CITY OF ALBUQUERQUE

RE: **Mountain Townhomes**
1406 Mountain Rd NW
Grading Plan Stamp Date: 2/26/19
Drainage Report Stamp Date: 2/26/19
Drainage File: J13D209

Based on the submittal received on 2/27/19, the grading plan and drainage report are approved for Plat.

RE: **Mountain Townhomes**
1406 Mountain Rd NW
Grading Plan Stamp Date: 12/11/18
Drainage Report Stamp Date: 12/11/18
Drainage File: J13D209

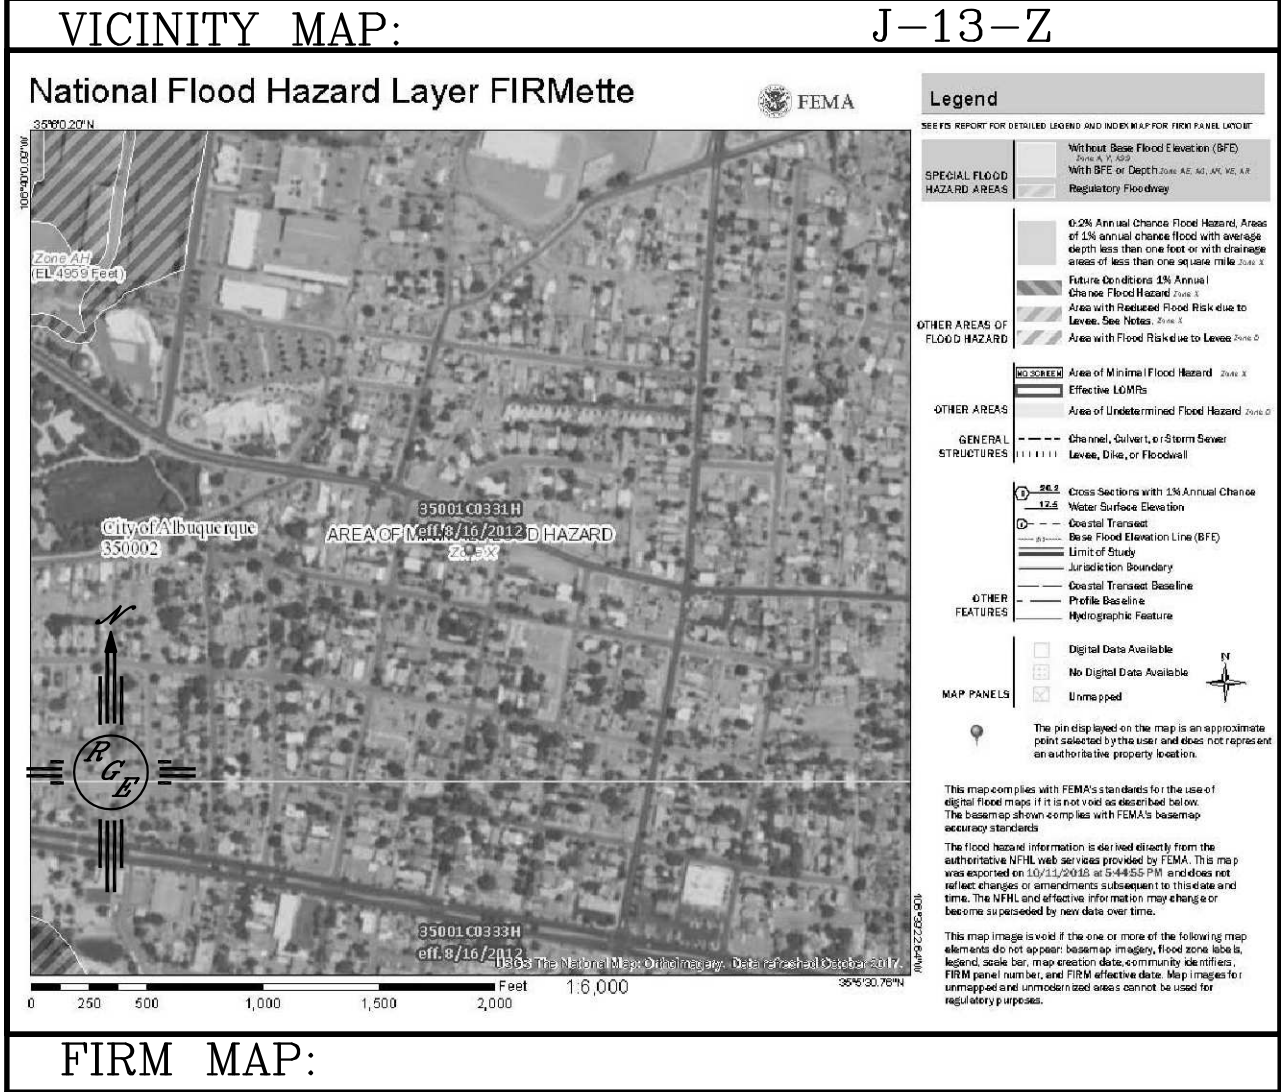
1. If an Infrastructure List is required by the DRB, then include the sidewalk culvert on it. Otherwise it can be built by SO-19. Please include the [standard SO-19](#) notes on the grading plan if true.
2. Provide the Bernalillo County recorded drainage easement granted by NMGasCo for discharging across their property.
3. On the Plat, provide cross-lot drainage easements as necessary across the proposed lots to support your grading plan. On the Plat, provide a drainage easement over the ponds and annotate using the [Plat Drainage Easement Note](#). This note replaces the need for a separate drainage covenant.
4. Payment of the Fee in Lieu (Amount = \$531, per Appendix A, *First Flush Calculation*) of onsite management of the SWQV must be made. Include a copy of the paid receipt when resubmitting.

*Topographic Survey of
Lots B, C, D and E of Block 44
Perea Addition
And the Vacated Portion of
Mountain Road, N.W.
Town of Albuquerque Grant, Projected
Section 18, Township 10 N., Range 3 E., N.M.P.M.
Albuquerque, Bernalillo County, New Mexico
February 2019.*

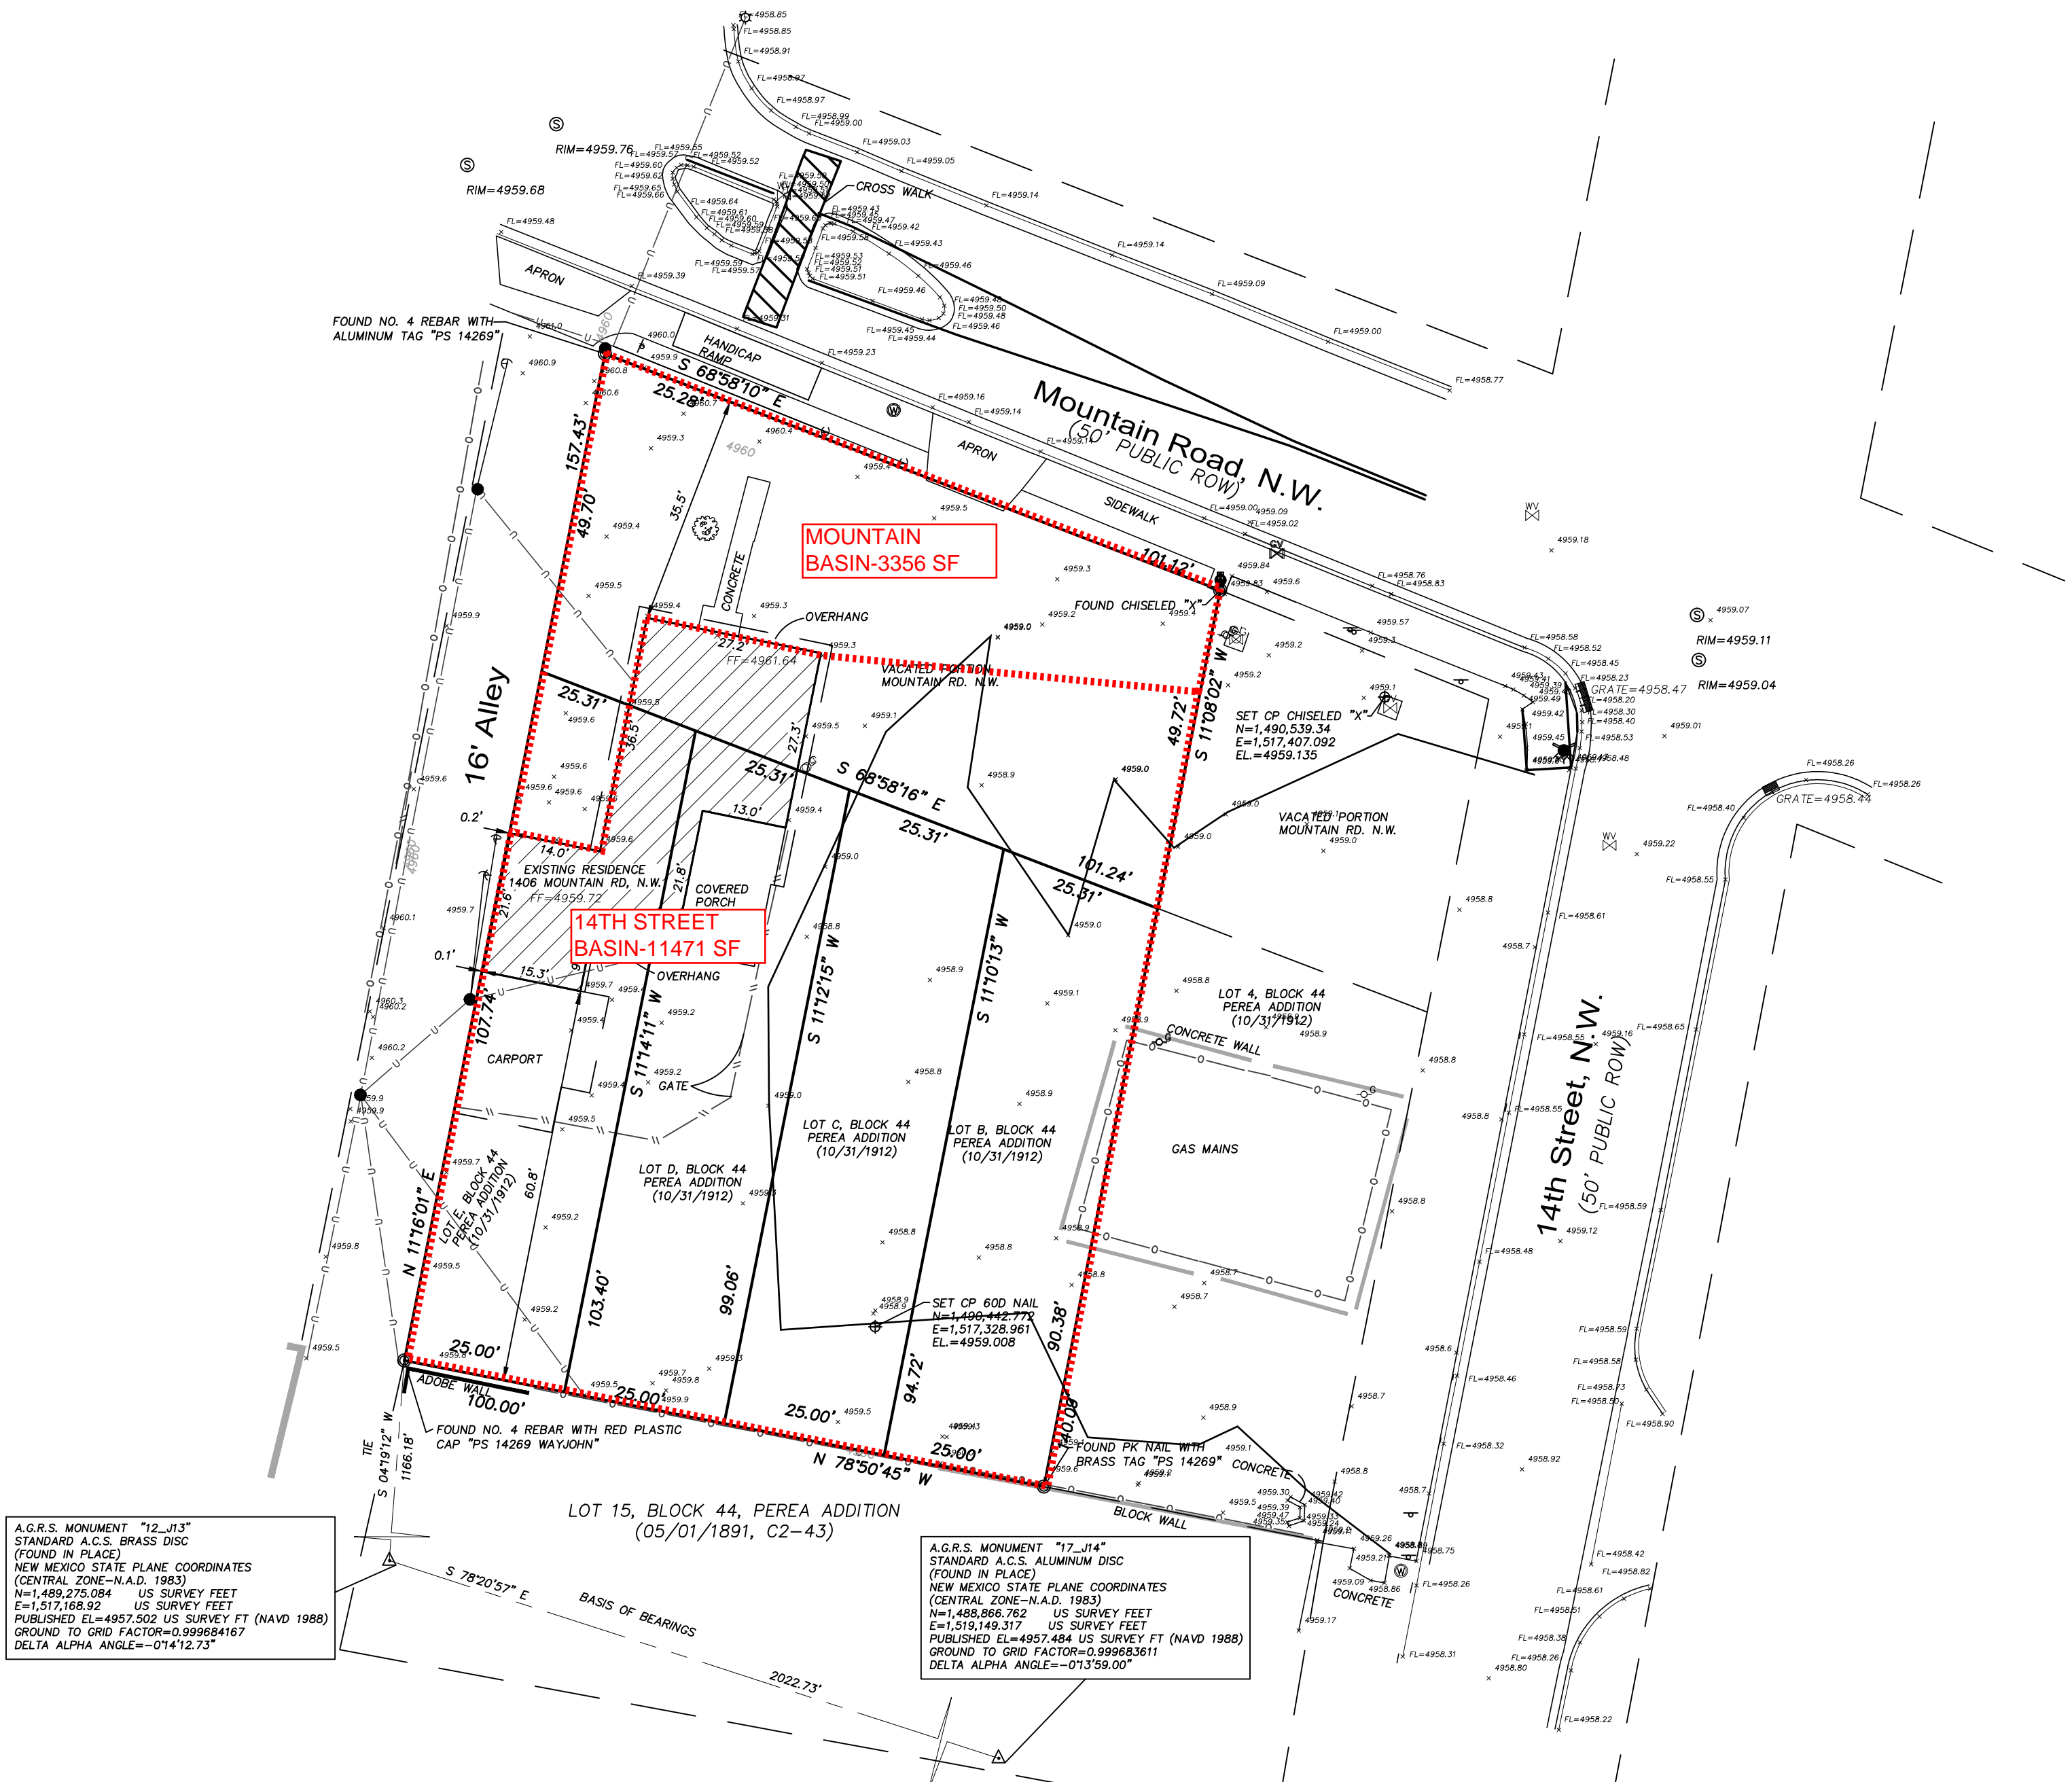
1. Provide a topographic and features survey, identifying current utilities, encroachments, easements, and structures. Include the existing topography under laid on the grading plan. Due to the flat nature of this site, supplemental spot elevations are likely needed to qualify existing drainage patterns. **We have provided separate existing conditions topo. When inserting onto grading plan the proposed spots were too difficult to see**
